Horsham  
District  
Council

# Gatwick Airport Northern Runway

National Infrastructure Project: TR020005

Principal Areas of Disagreement Summary Statement  
Version 3 (clean version)

Drawn date:
September 2023

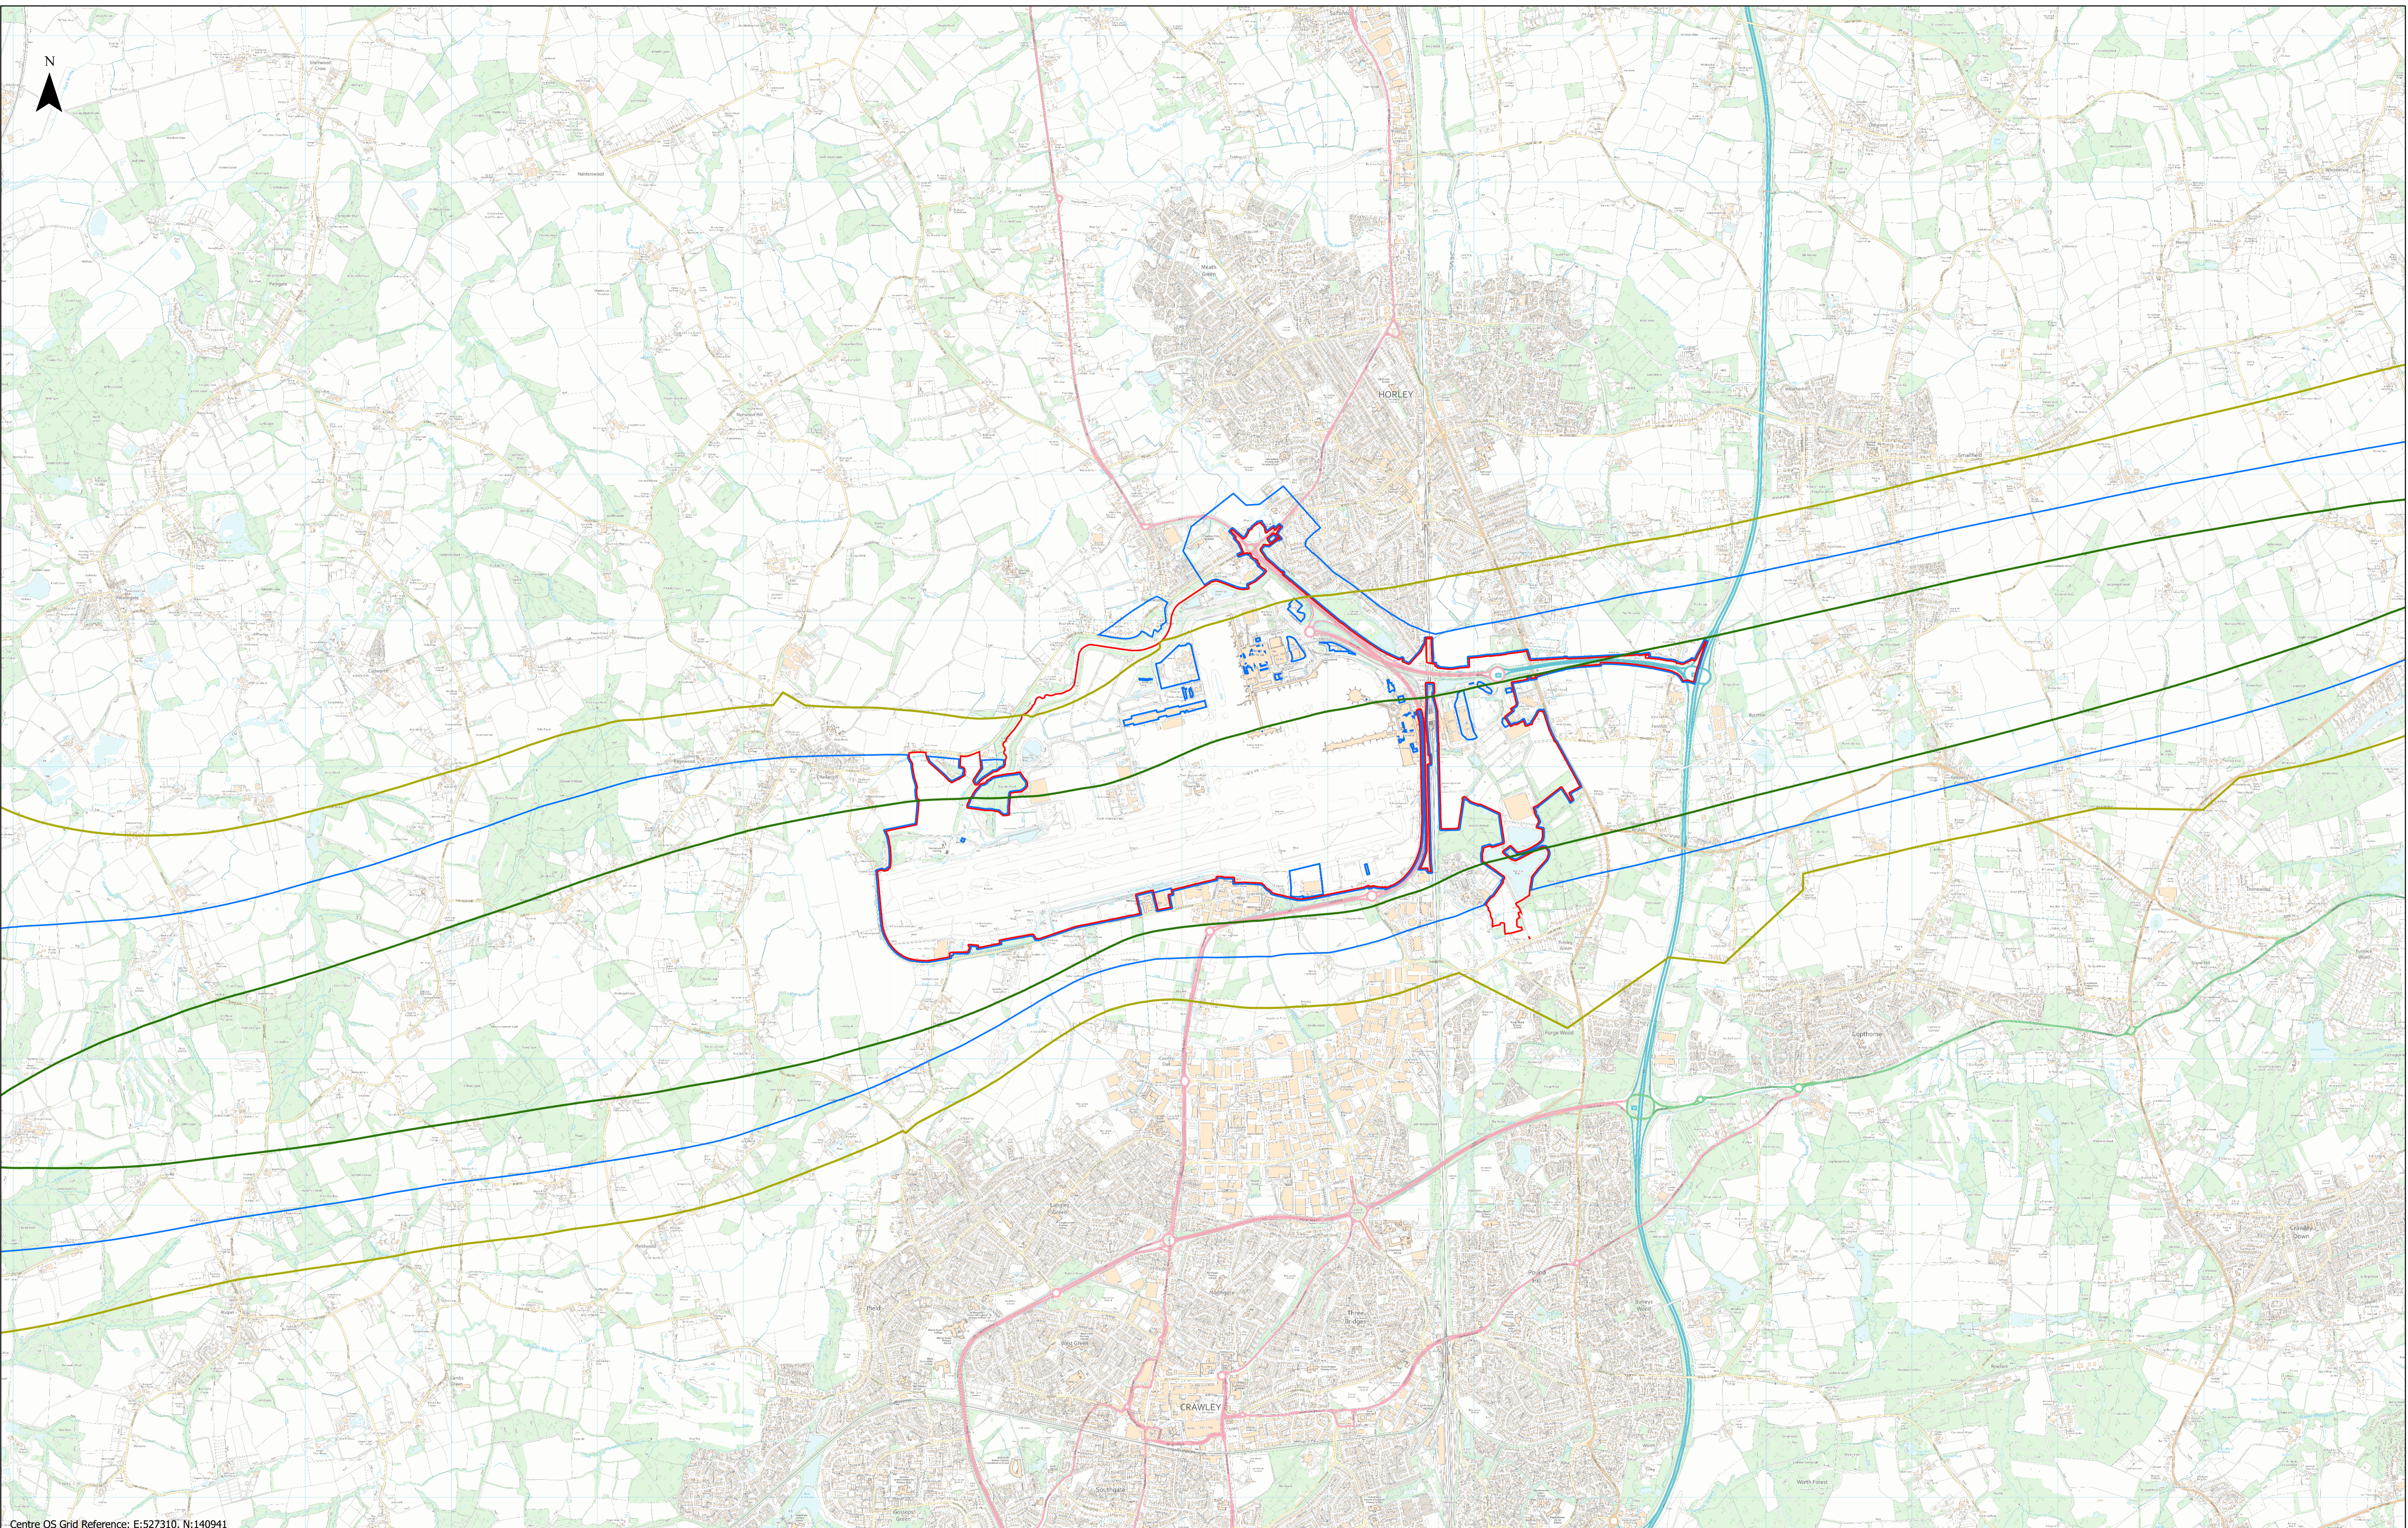
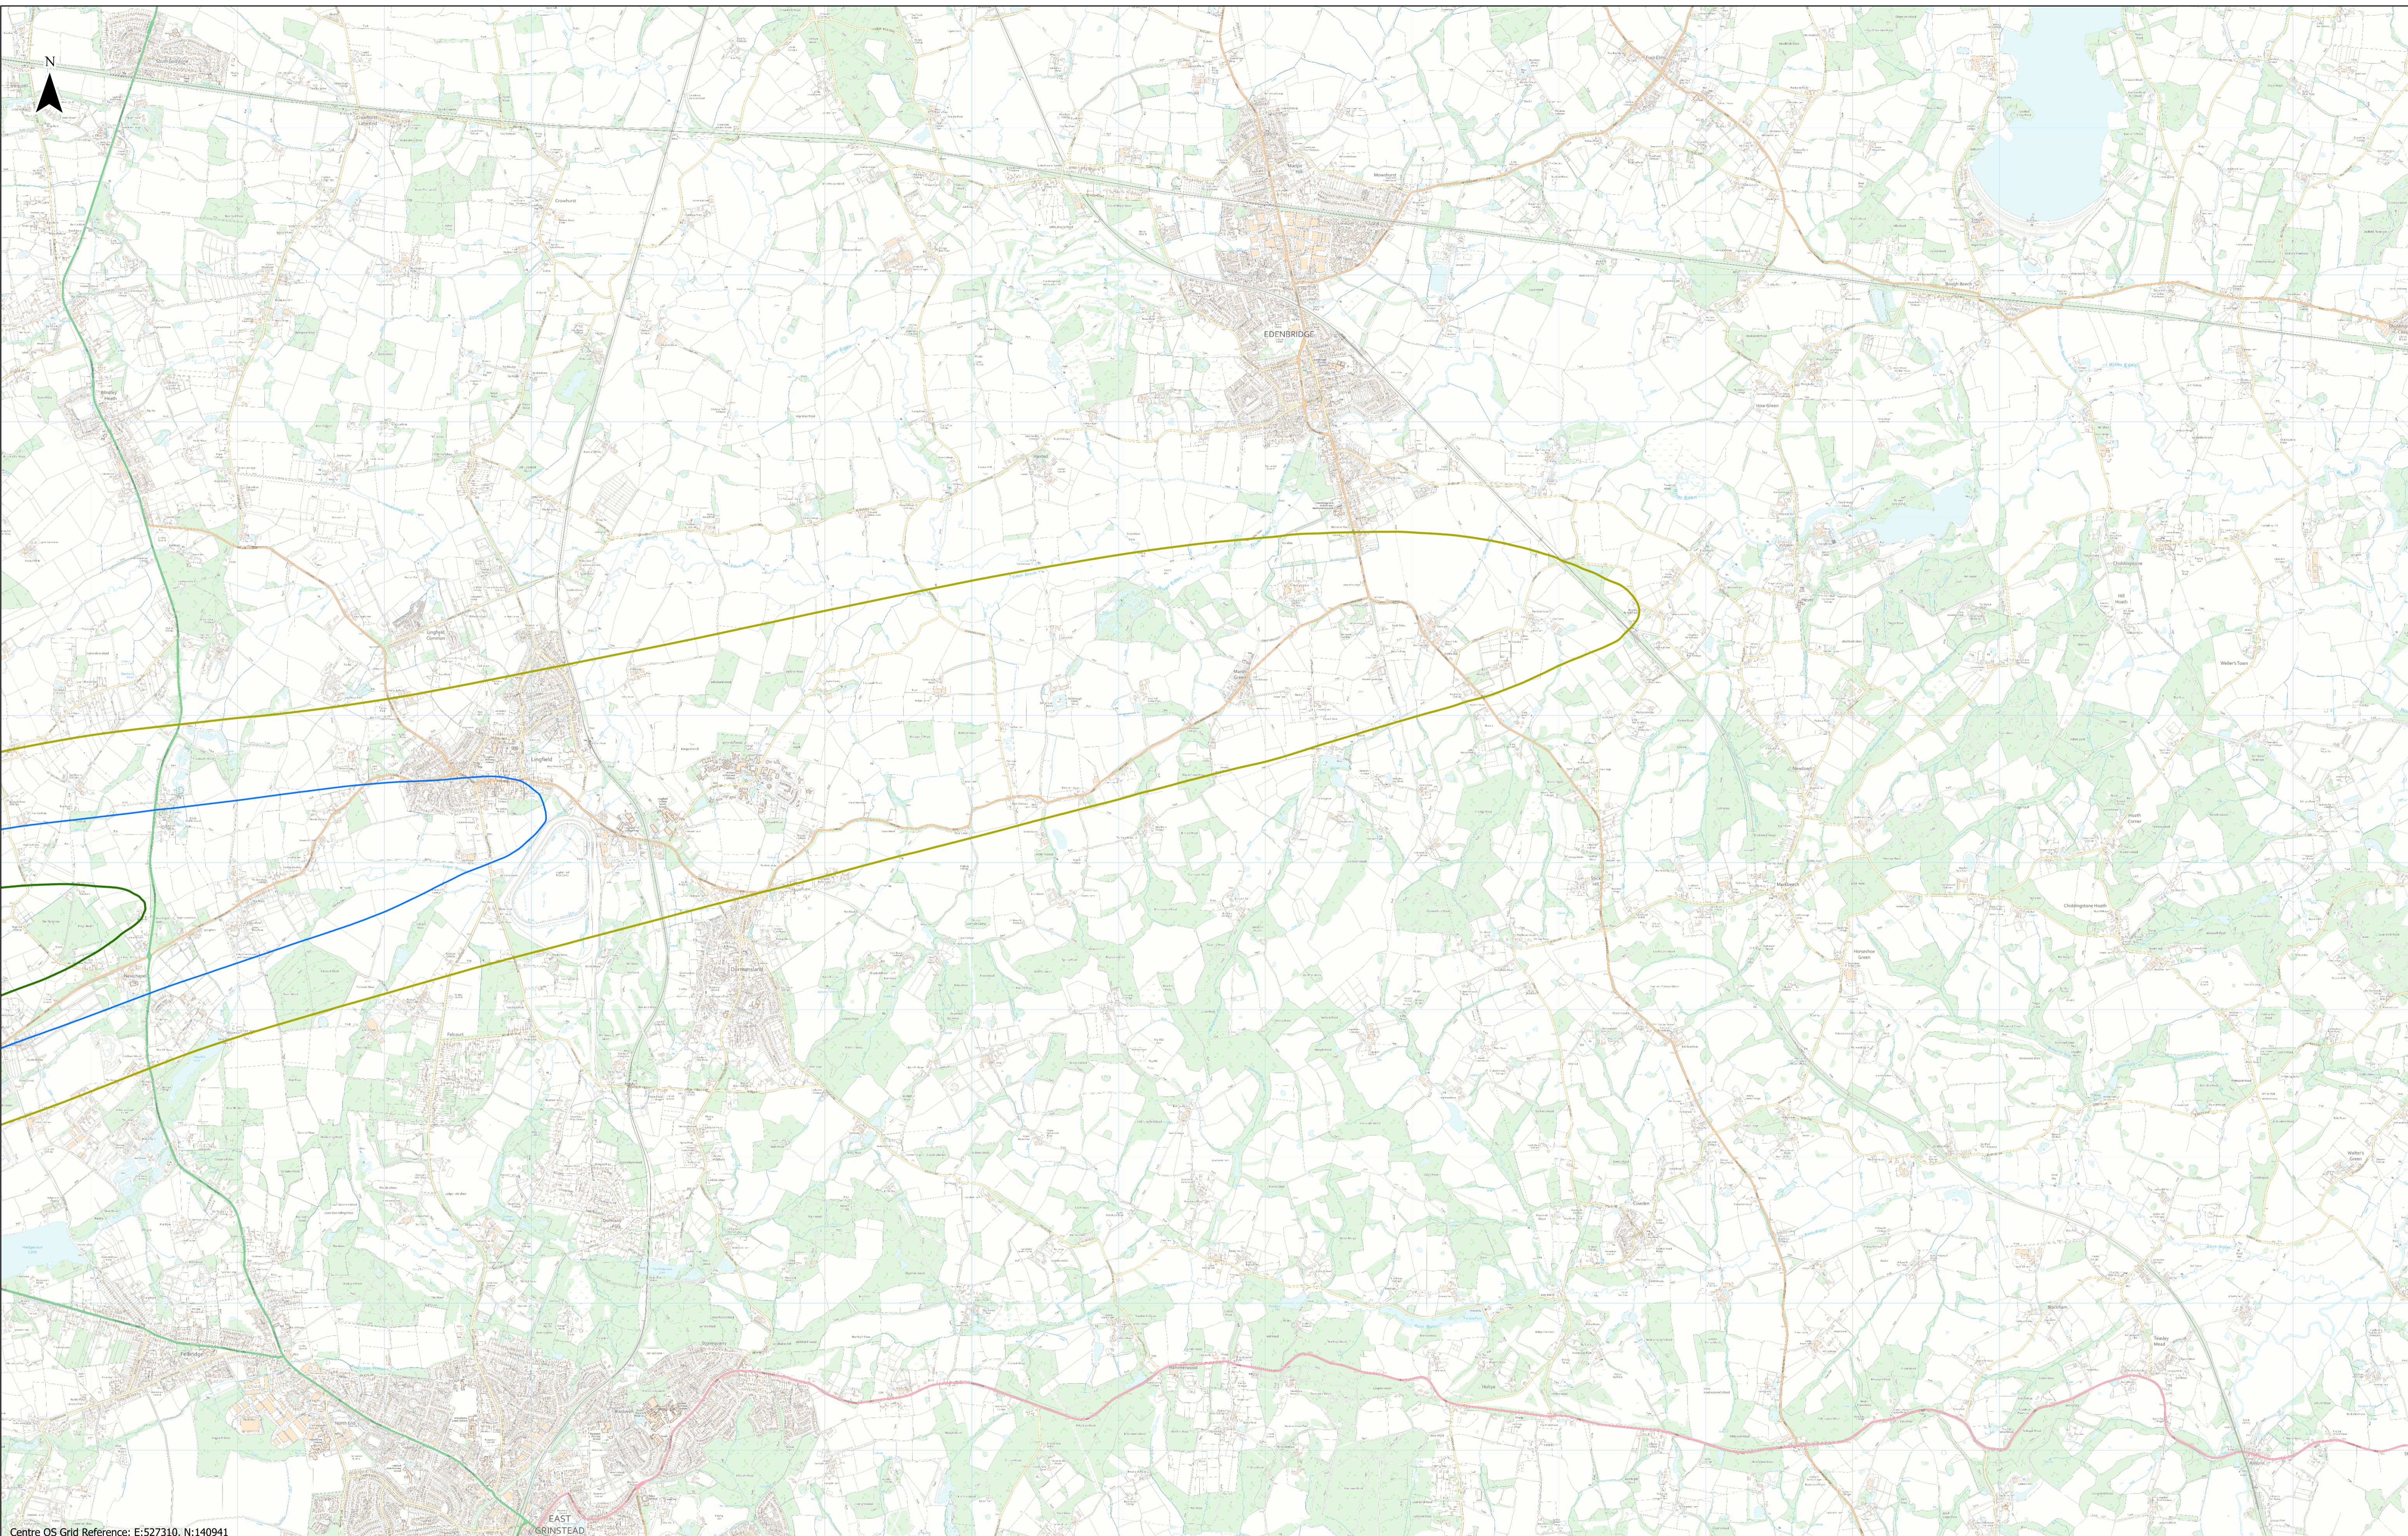
4.9	Noise Insulation Scheme	The noise insulation scheme is not sufficient to protect those who will suffer adverse effects of noise and deal	The Applicant will need to improve the offering based on consideration of a wider range of	Uncertain
